Add PCD File No. PPR-21-024
Unresolved.

DRAWN BY: D.E. WATTS DATE: 4-2-21 DWG. NO.: 20-5509-06 SURVEYED BY: DEW, ESW, 6-26-19, 9-24-20	APPROVED BY: PROJ. NO.: DWG.:	REVISIONS 9-27-21 REVISED PER COUNTY REVIEW COMMENTS DEW	OLIVER E. WATTS CONSULTING ENGINEER COLORADO SPRINGS	PROJECT 10659 MALTESE POINT LOT 11, ROLLING THUNDER BUSINESS PARK EL PASO COUNTY	SHEET NAME GRADING AND EROSION CONTROL PLAN	SHEET NO. 1 OF 2
---	-------------------------------------	--	--	---	---	---------------------

DRAWN BY: O.E. WATTS	APPROVED BY:	REVISIONS 3-16-21 REVISED BUILDINGS DEW	PROJECT 10659 MALTESE POINT LOT 11, ROLLING THUNDER BUSINESS PARK EL PASO COUNTY	SHT. NAME GRADING AND EROSION CONTROL PLAN	SHT. NO. 2 OF 2
DATE: 4-2-21	PROJ. NO.	9-27-21 REVISED PER COUNTY REVIEW COMMENTS DEW			
DWG. NO.: 20-5509-07	DWG.				
SURVEYED BY: DEW, ESW, 6-26-19,9-24-20

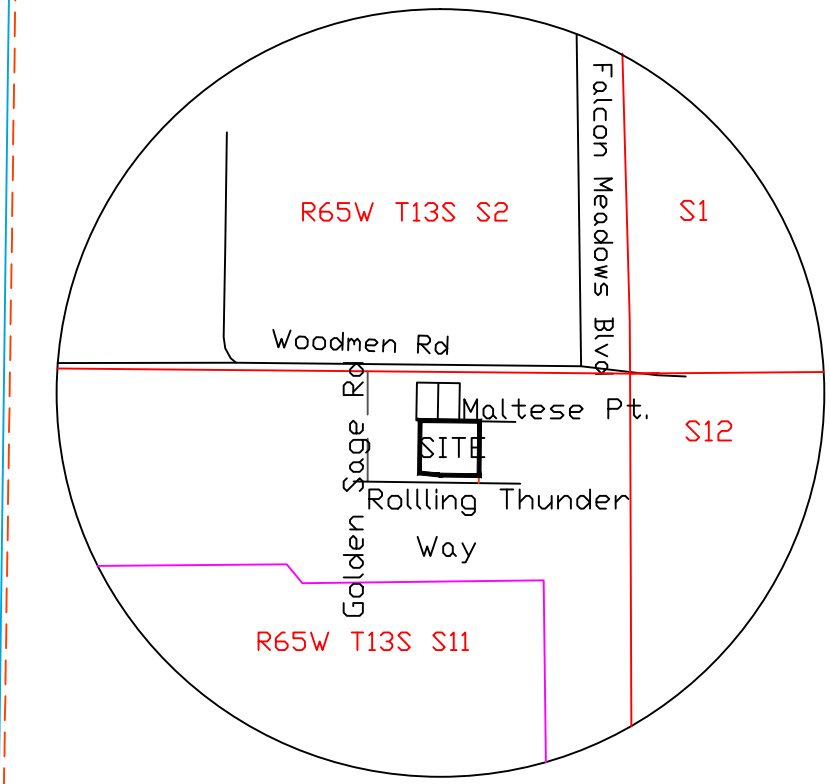
Where does the silt fence end?
Note: Consider using a different line type so we can still see the SF line type even if it overlaps another line type. (see two line type options below that might work better in situations like this)

include inlet protection (interim)
Unresolved

GEC Checklist Item p.
The limit of disturbance cannot also be the cut/fill line. It is not clear where there will be cut and where there will be fill at the Site.

GEC Checklist Item d.
line type doesnt match legend

provide curb return radius at the proposed access. Be sure to match the site plan

GEC Checklist Item d.
show VTC symbol on the plans, as shown on the legend.

provide a leader to the spot elevations shown to know where they occur. Are these for the retaining wall? please clarify

expand the limits of disturbance to include work in the ROW

Please identify the curb type and indicate that it will match existing. Add the EPC standard curb detail SD-2-20 to the plans.

It appears that there may be a conflict with the proposed retaining wall and existing manhole and storm pipes. Please provide a detail/cross section showing how this will work.

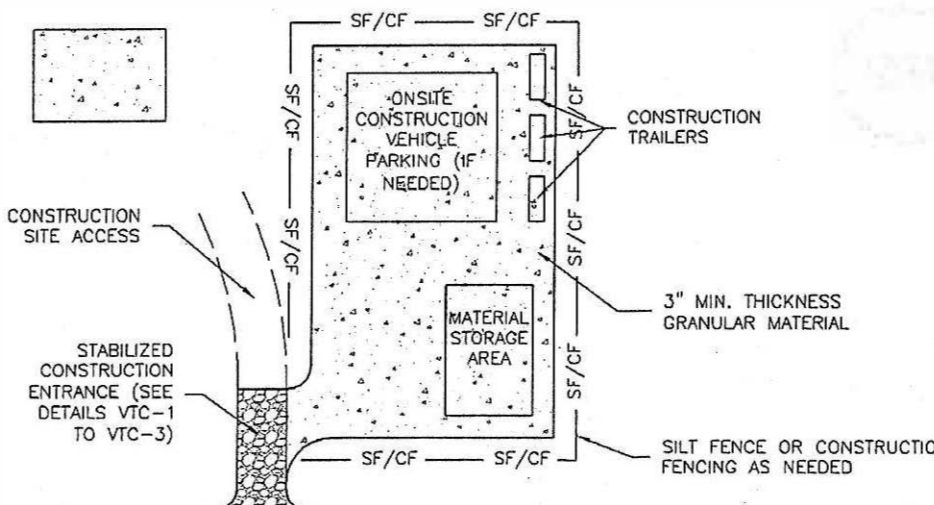
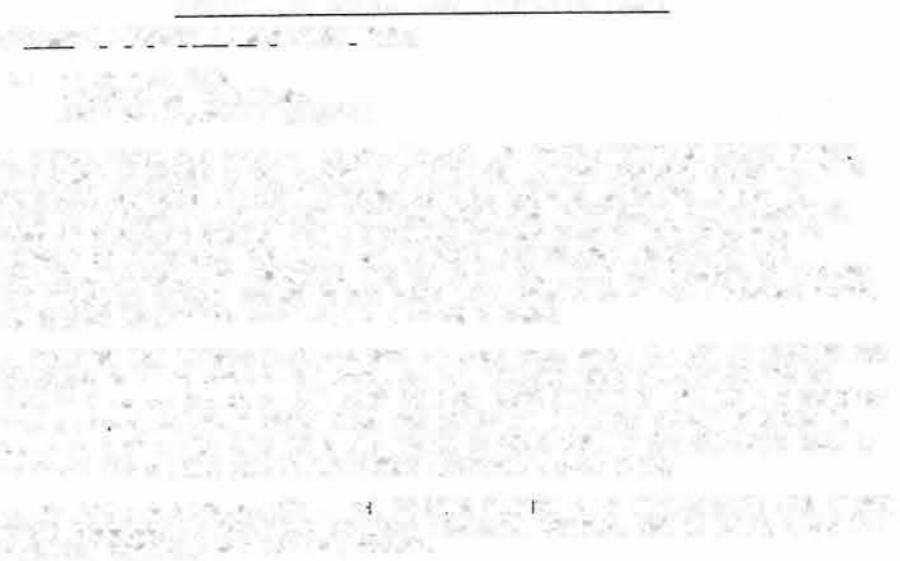
Identify on the plan where this detail will occur. There is areas on the plan that appear that the height of the proposed retaining wall is less than 4'-0" where possibly a different detail should be specified.

Please provide a note indicating to protect in place the existing storm facilities and for the contractor to verify with Pikes Peak Regional building whether a building permit and surcharge loads will be required
